Office of  
Environment  
& Heritage

DOC19/32912  
SSD 8800

**Parramatta Leagues Club Hotel (SSD 8800) – 1 Eels Place, Parramatta - Environmental Impact Statement**

### Leagues Club Hotel (SSD 8800) – 1 Eels Place, Parramatta - Environmental Impact Statement

TREE RETENTION AND REMOVAL PLAN

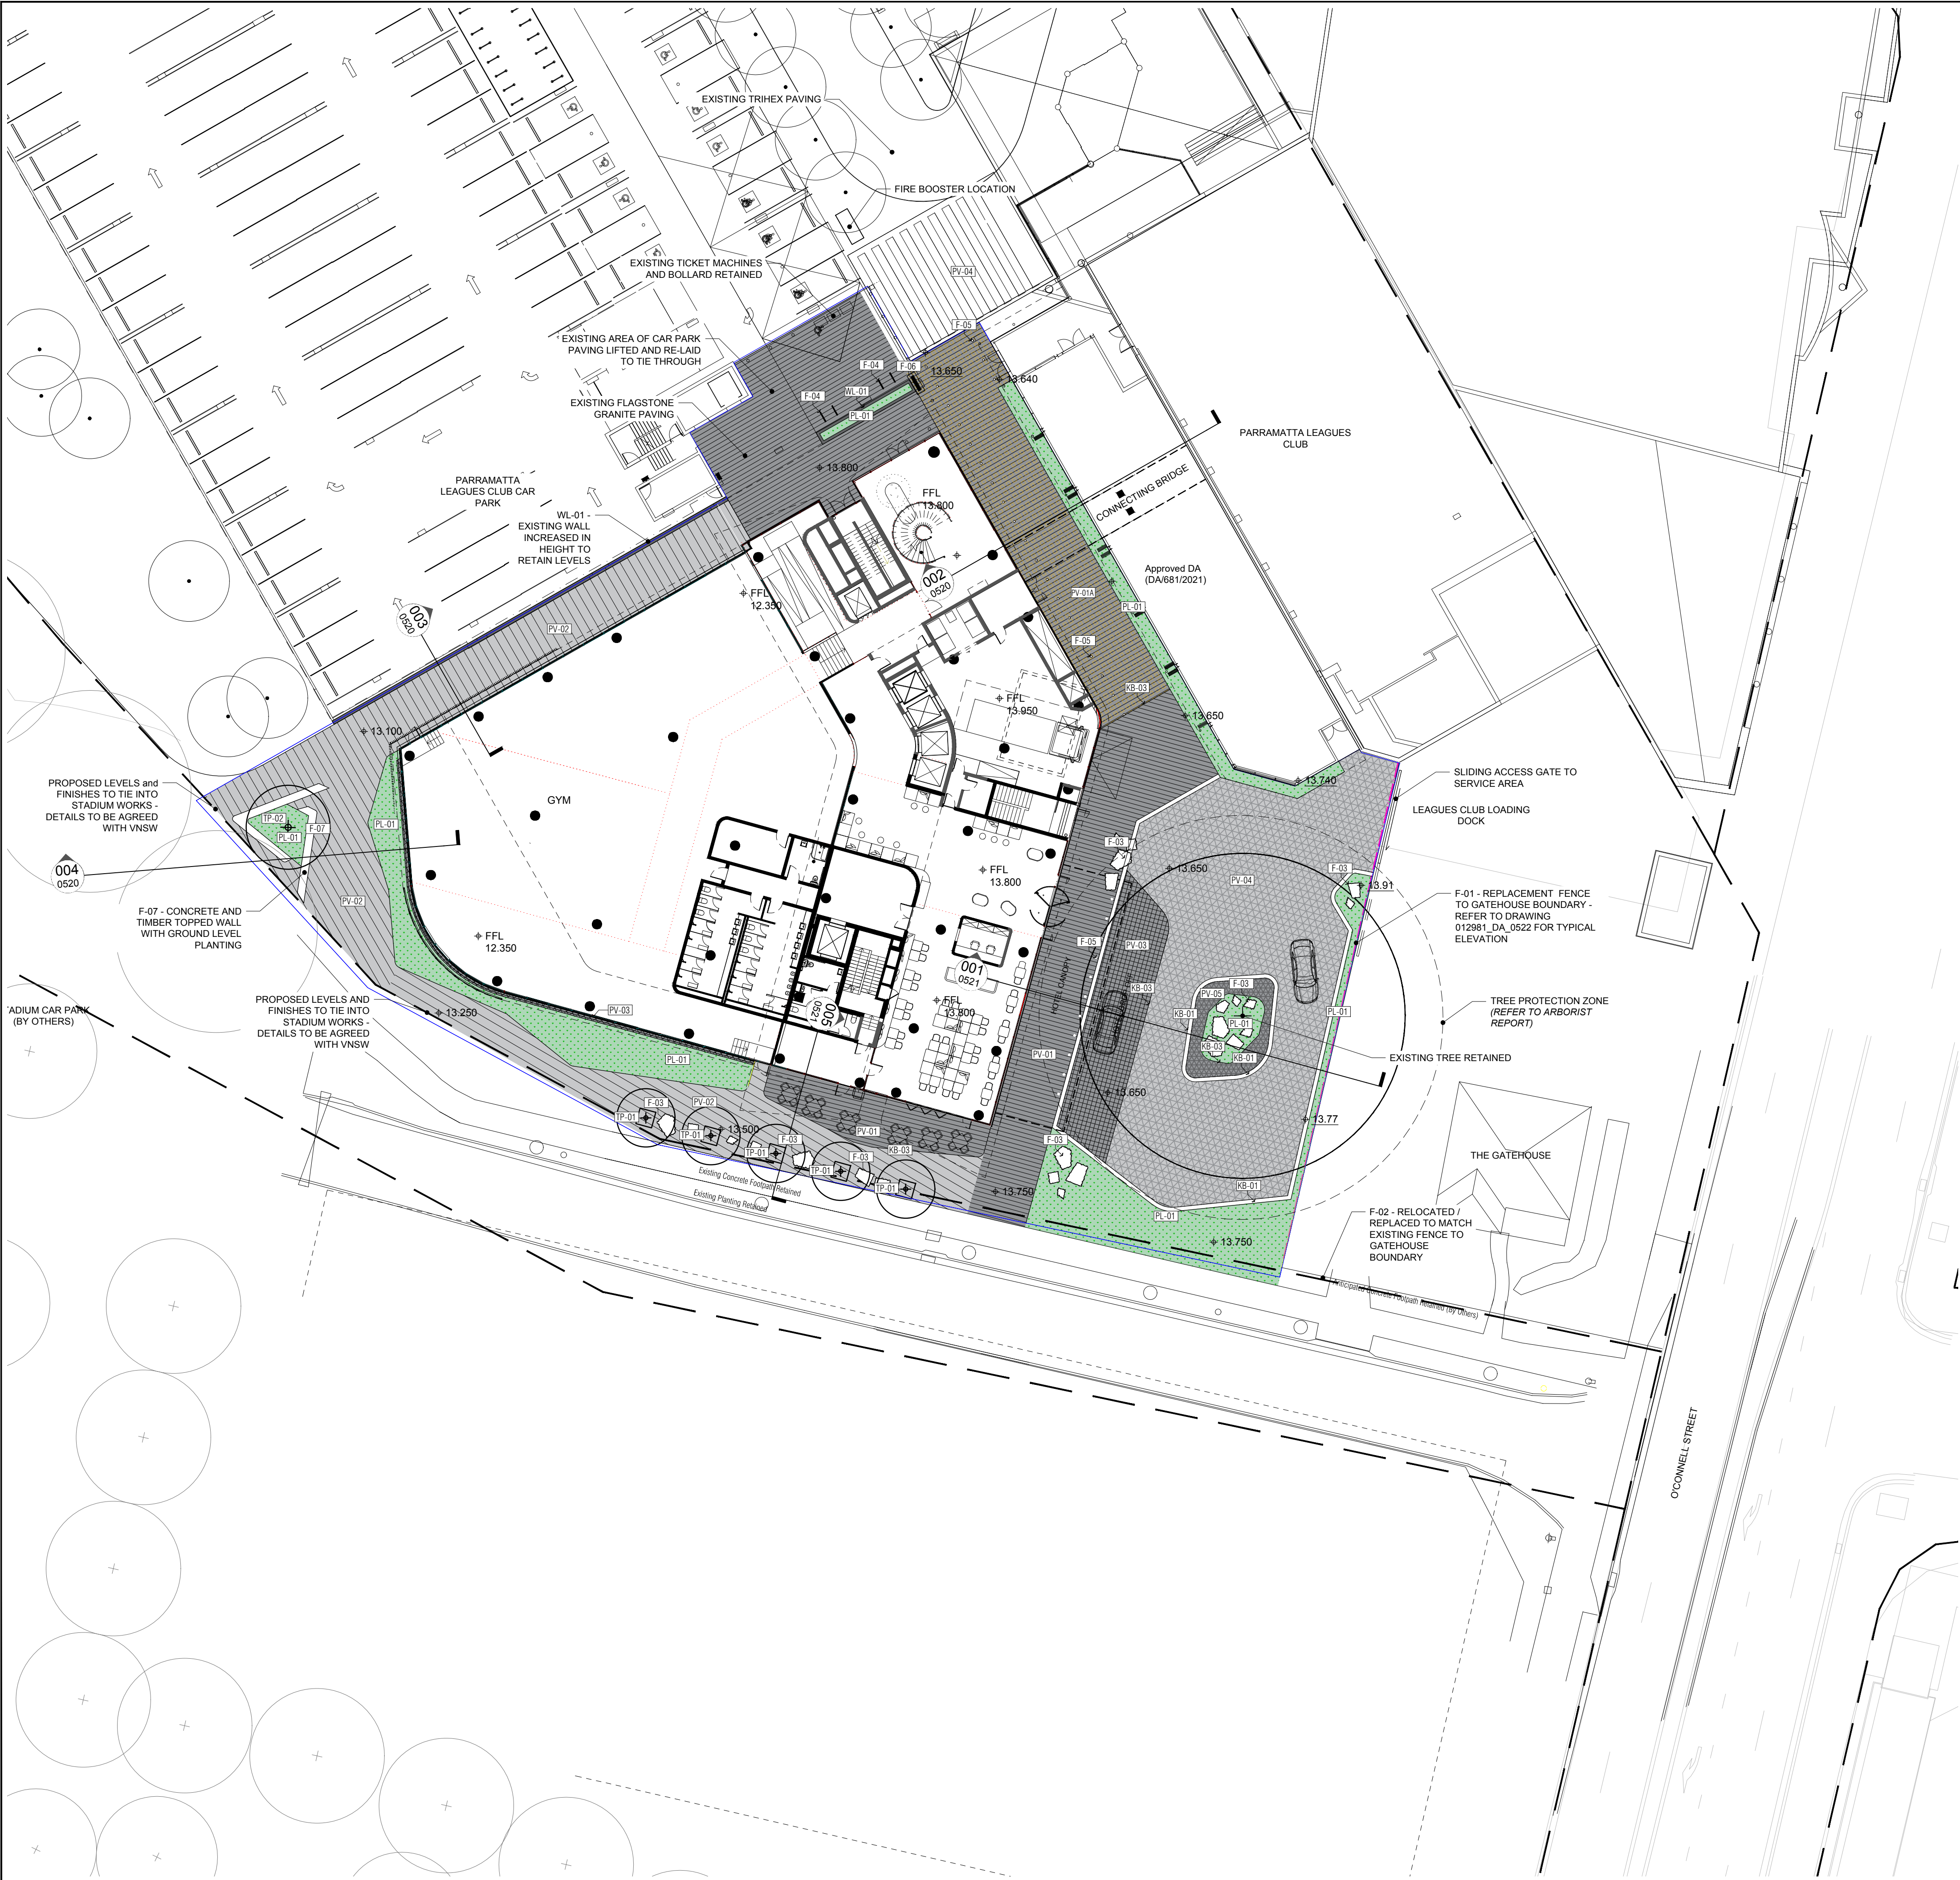
The AIA recommends installing 11 advanced size (8-15m mature height) native trees from minimum 200L containers to replace the seven trees proposed to be removed (pages 8 and 10). OEH supports the planting of advanced local native tree species, as the removal of the existing trees and the benefits they provide, can take decades for a juvenile tree to replace. It is suggested that where possible more than 11 trees are planted on the site. If the project is approved, it is recommended a condition of consent is included to plant advanced size (8-15m mature height) local native trees from minimum 200L containers.

- 1) Landscaping must use a diversity of local provenance species (trees, shrubs and groundcovers) from the native vegetation community (or communities) that once occurred on the site to improve biodiversity (rather than use exotic plant species or non-endemic native species). A Landscape Plan must be prepared for the site and include details on:
  - (a) the native vegetation community (or communities) that once occurred on the site
  - (b) a list of local provenance tree, shrub and groundcovers to be used in the landscaping, the quantity and location and
  - (c) the pot size of the local native trees to be planted. Tree planting at the site must use advanced and established local native trees with a minimum plant container pot size of 200 litres, or greater.

FILENAME \\sydproj\fs03\012981-61A-P\Working\AutoCAD\01_SD\Sheet\012981_DA_0510 Ground Level Landscape Plan.dwg

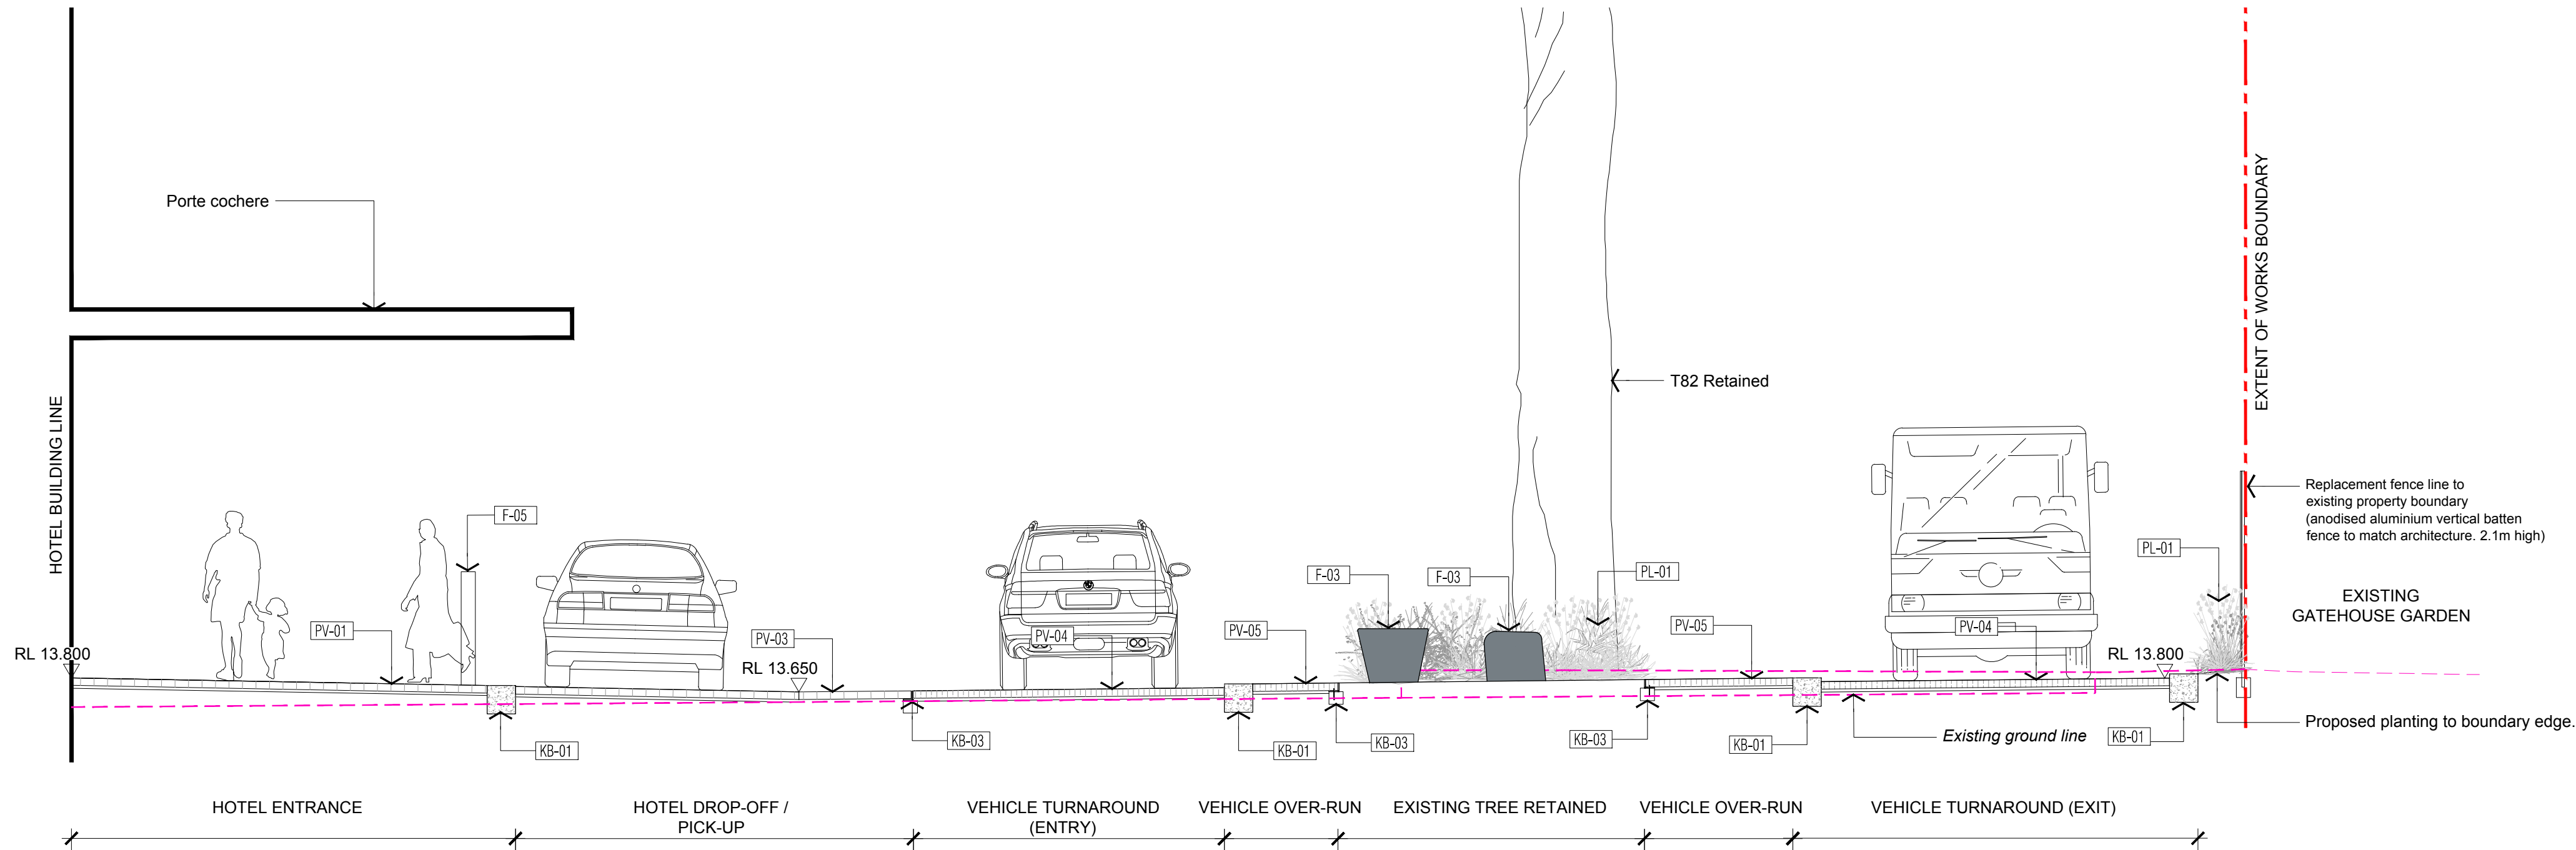
The Ground Level Landscape Plan shows the proposed development will predominantly provide hard paved areas at ground level with some native grass and shrub planting and trees. If possible, it is recommended the area proposed for hard paving is reduced and additional areas of natural soil and native vegetation planting are provided to improve biodiversity.
